Re: Falcon Marketplace Preliminary Plan (SP-17-001) Response 4

Please accept this response letter to your review 3 comments dated June 20, 2017.

EXISTING DRAINAGE CONDITIONS

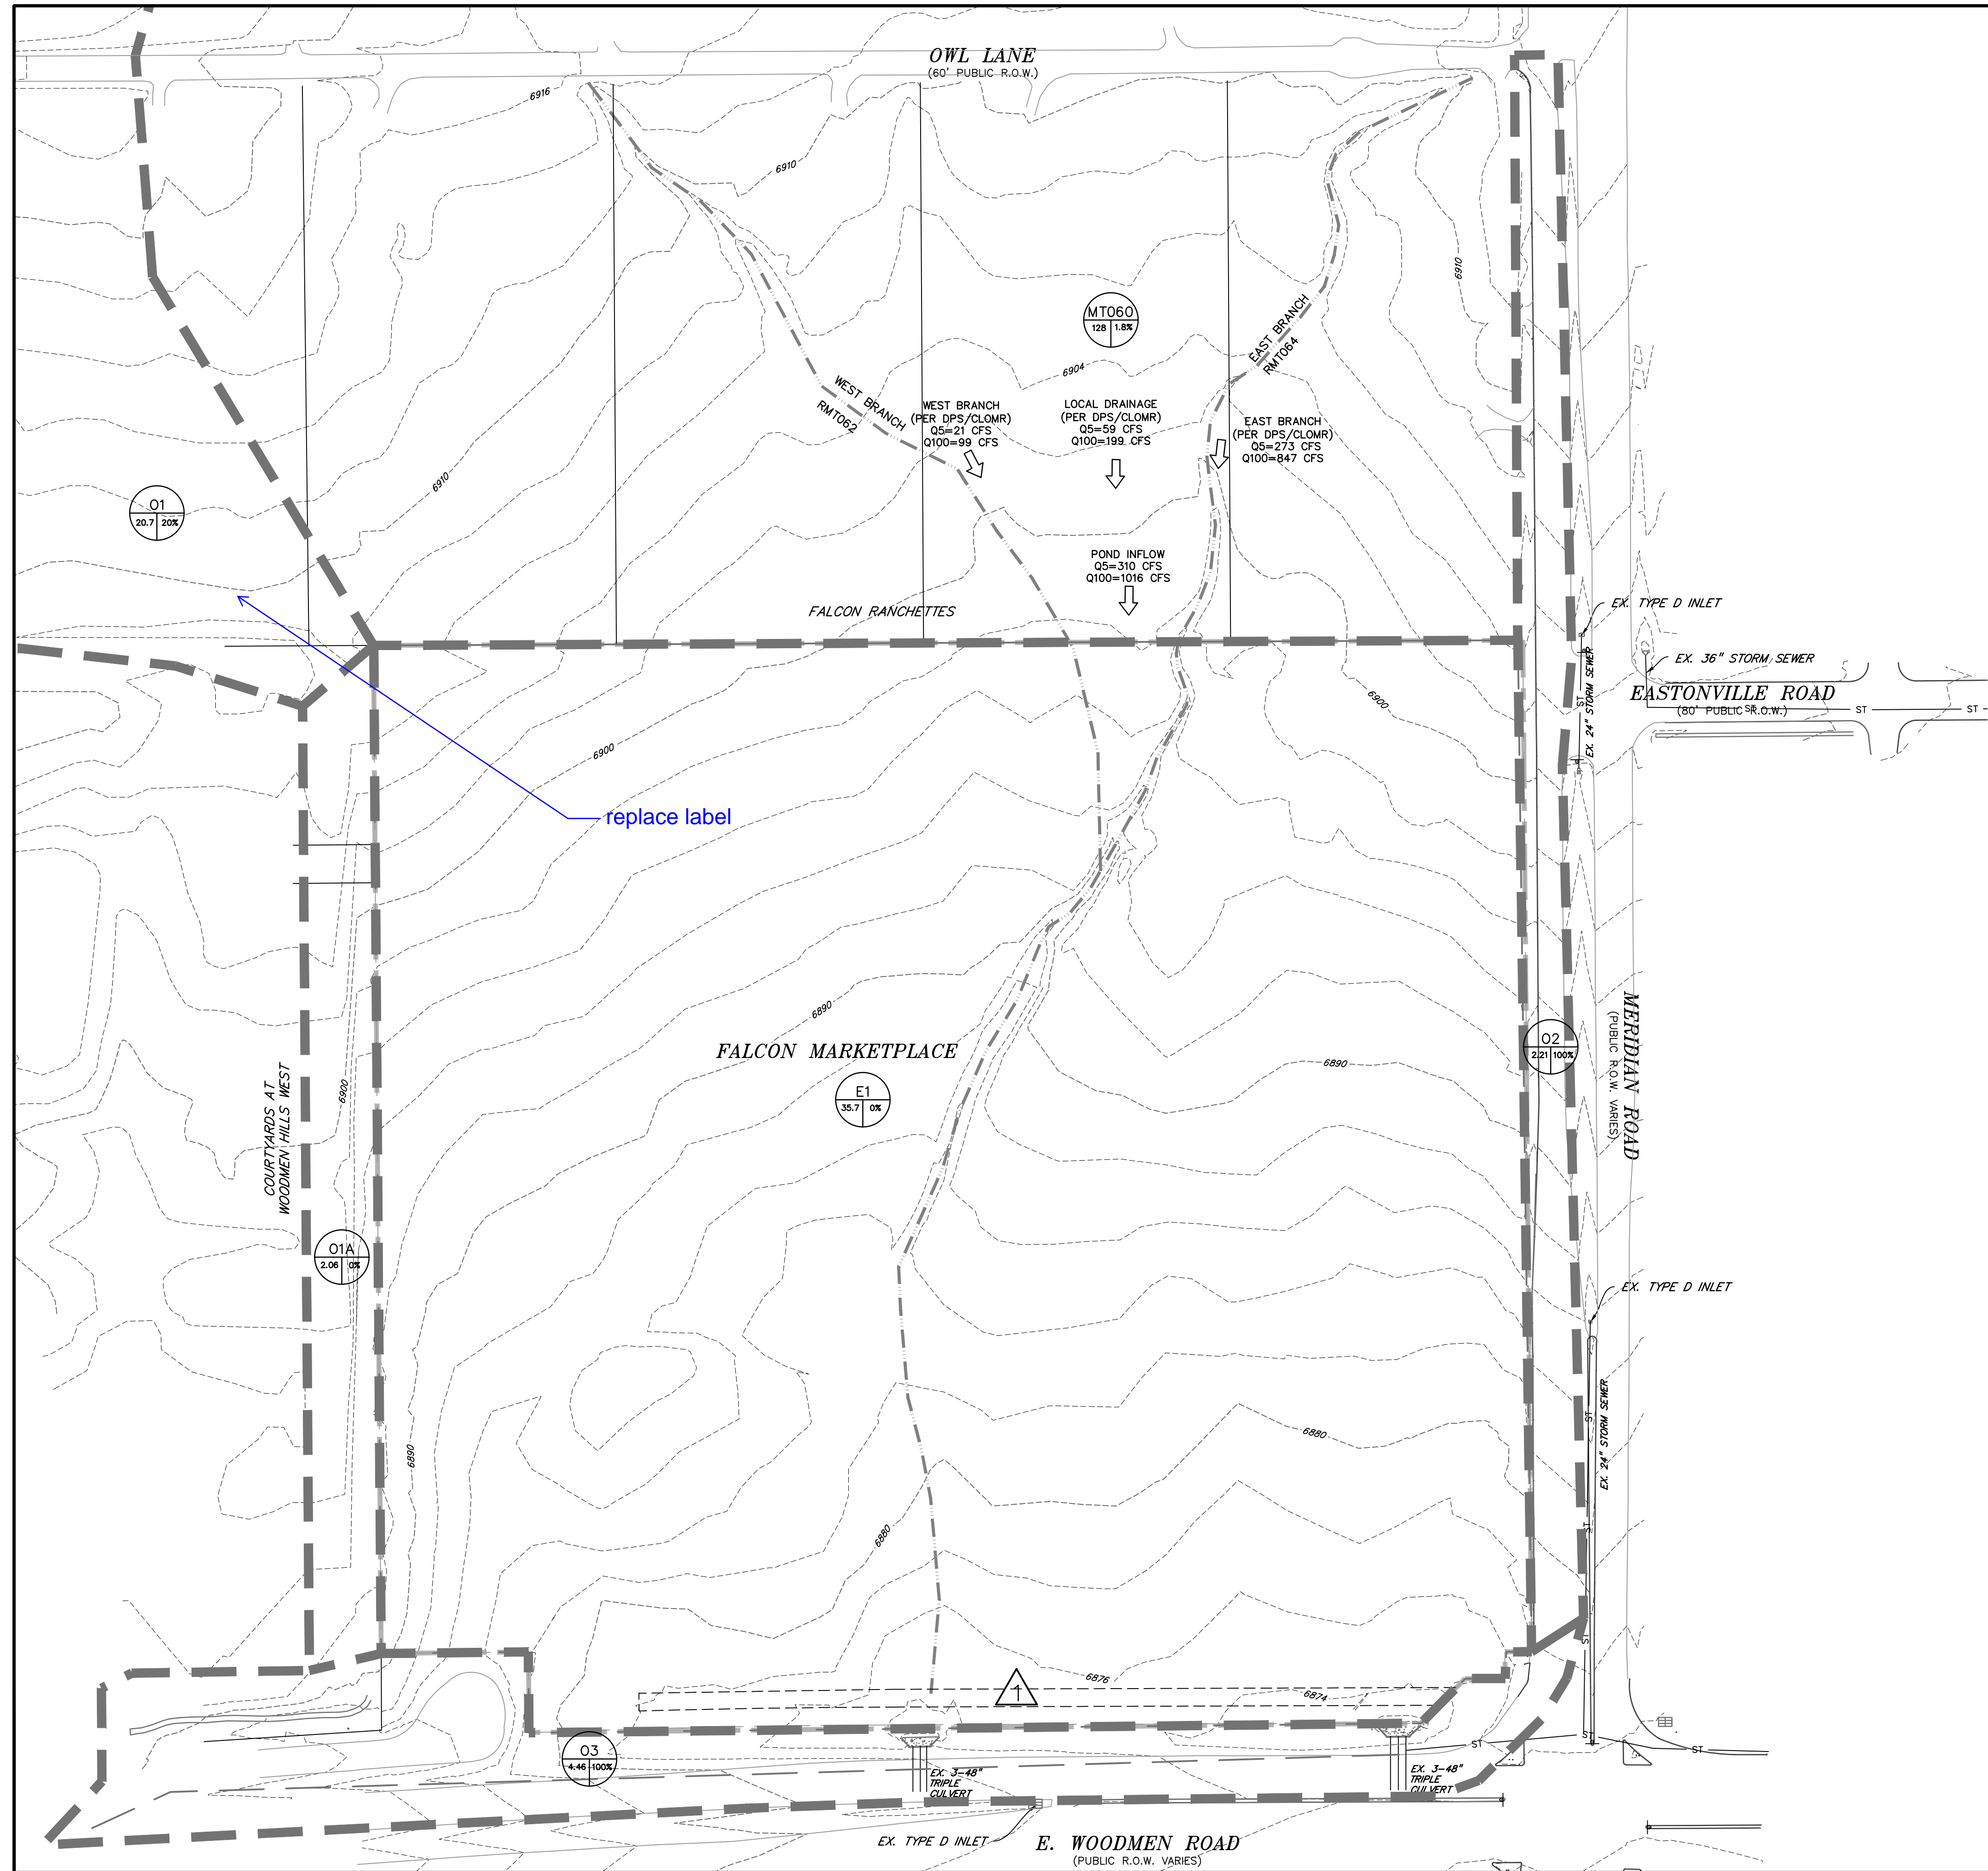
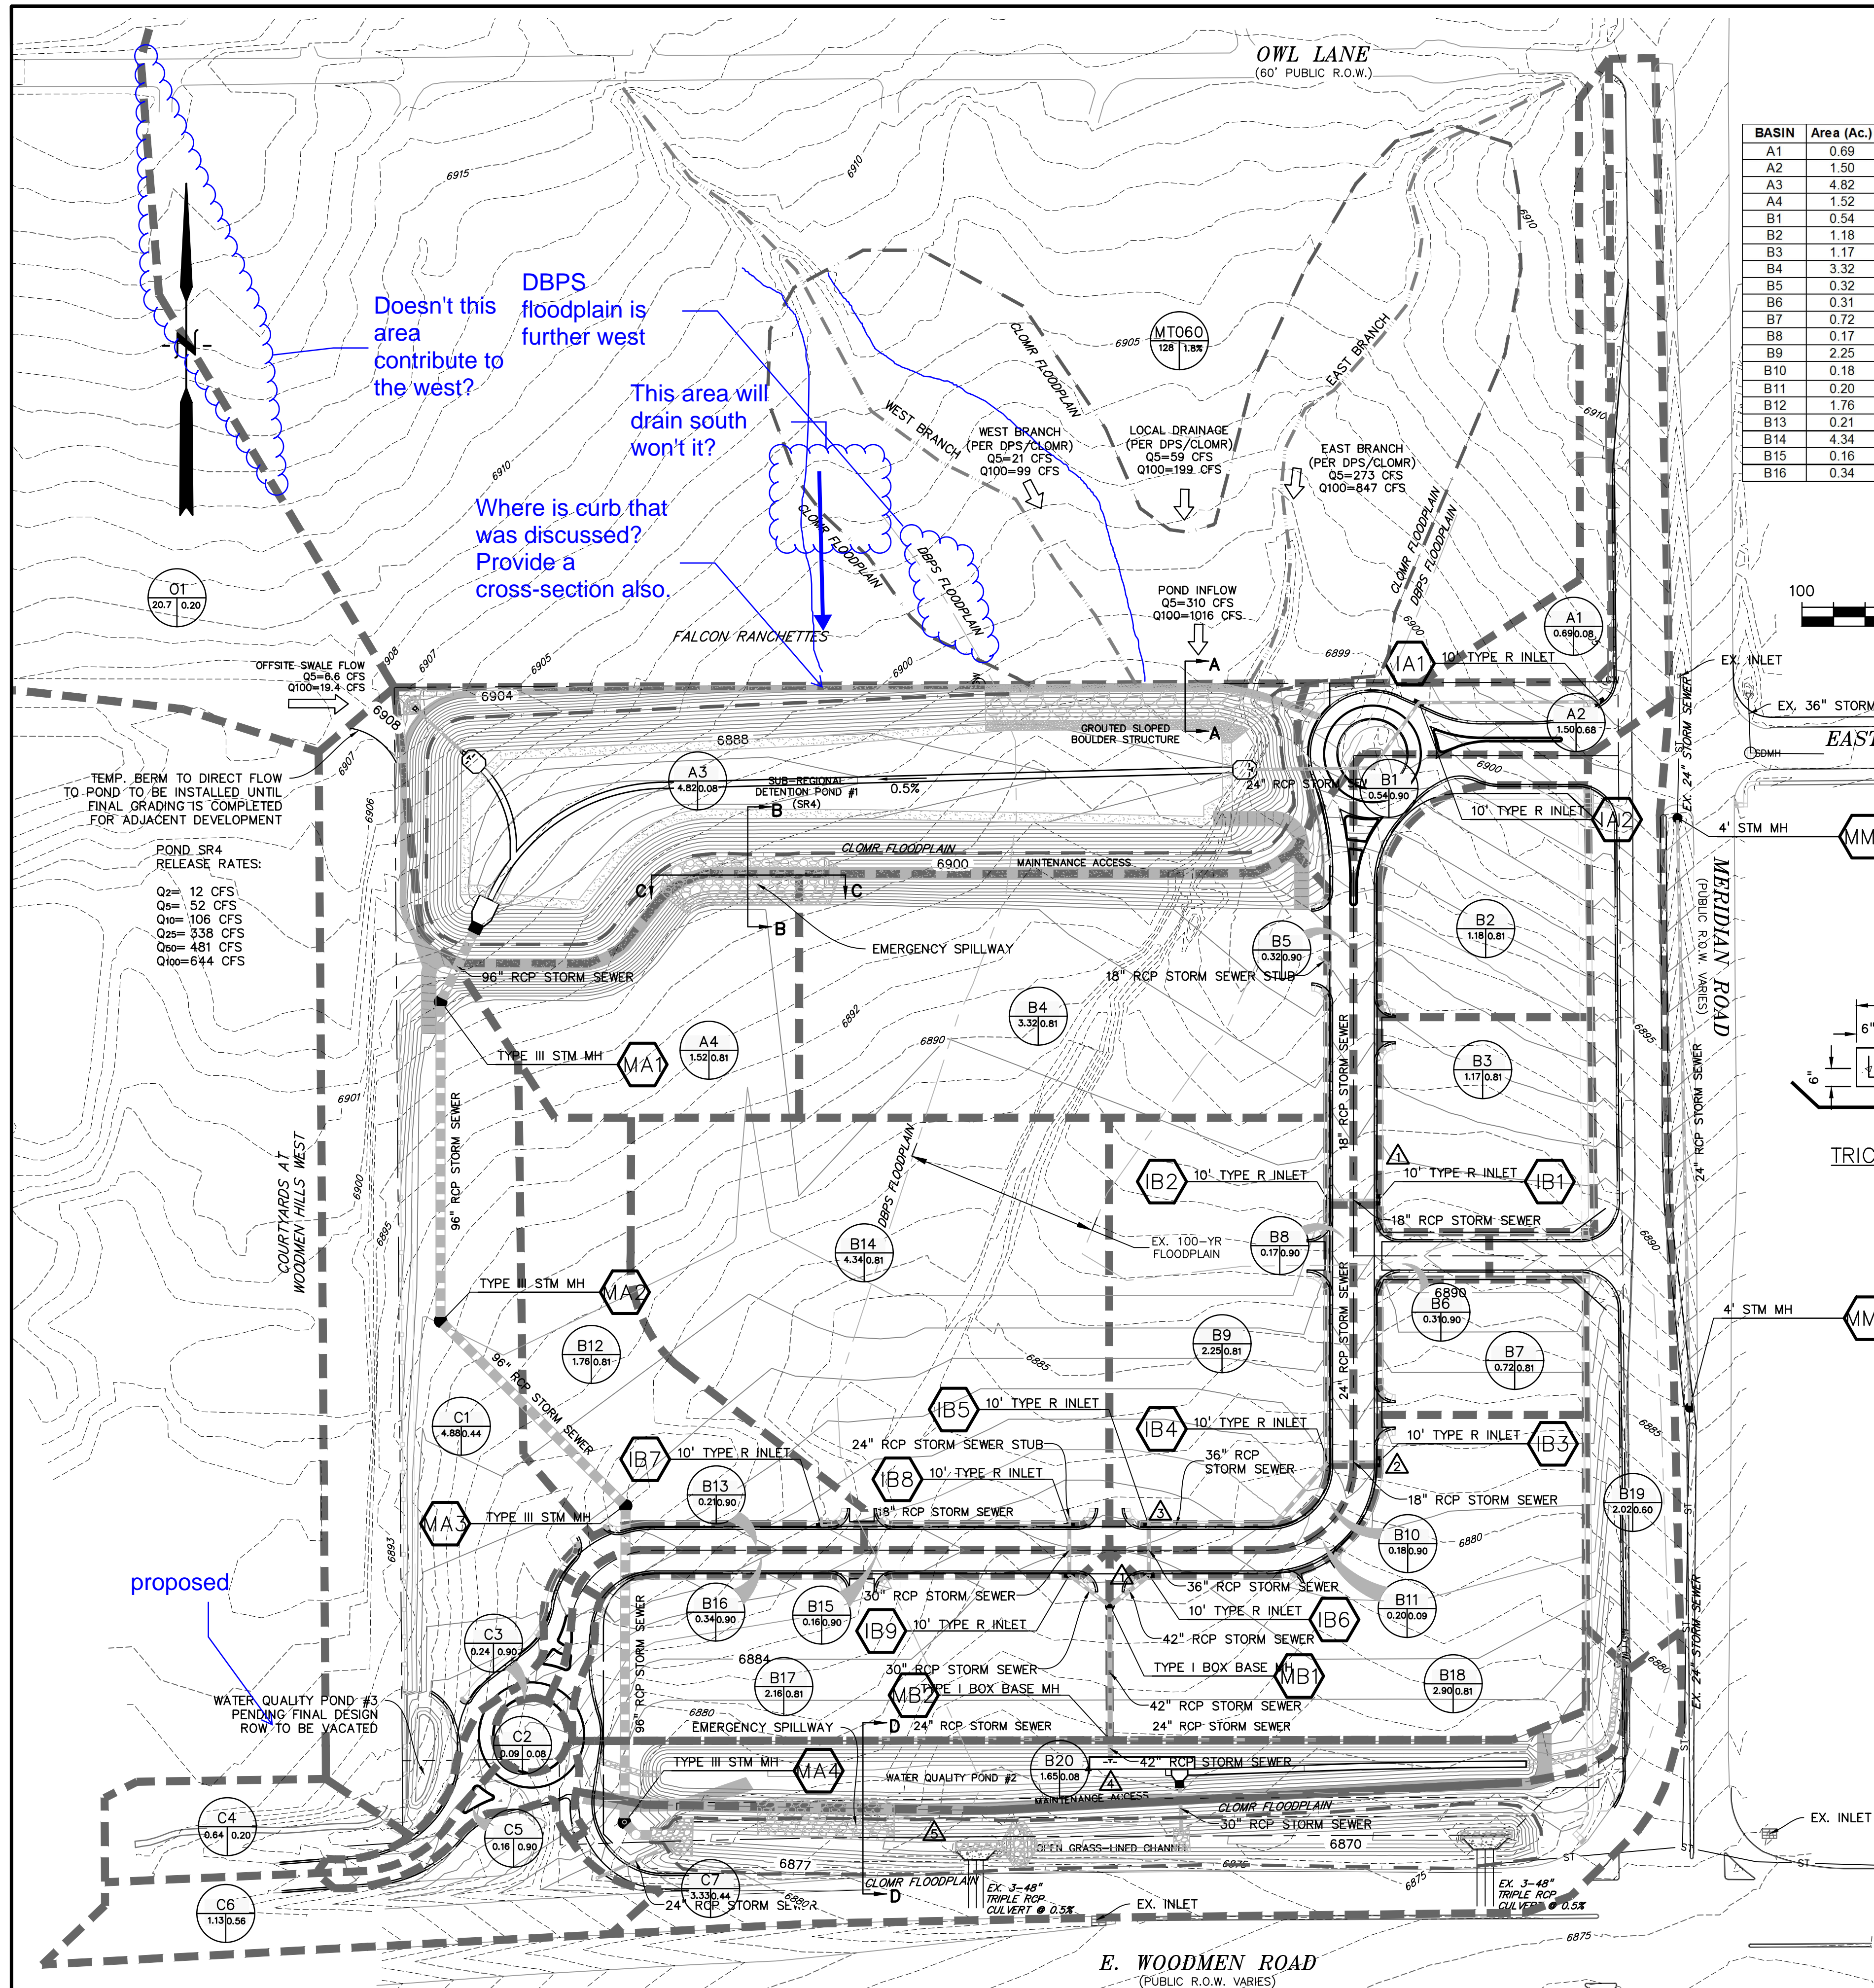
- Approximate location of existing and proposed structures Approximate location of:
 - Watercourses, existing bodies of water, and other water forms Not Addressed, Add the floodplain line existing and proposed after LOMR information to the prelim plan map sheets **Existing floodplain linework already shown on grading sheet. Proposed and existing floodplain linework now added to other sheets.**
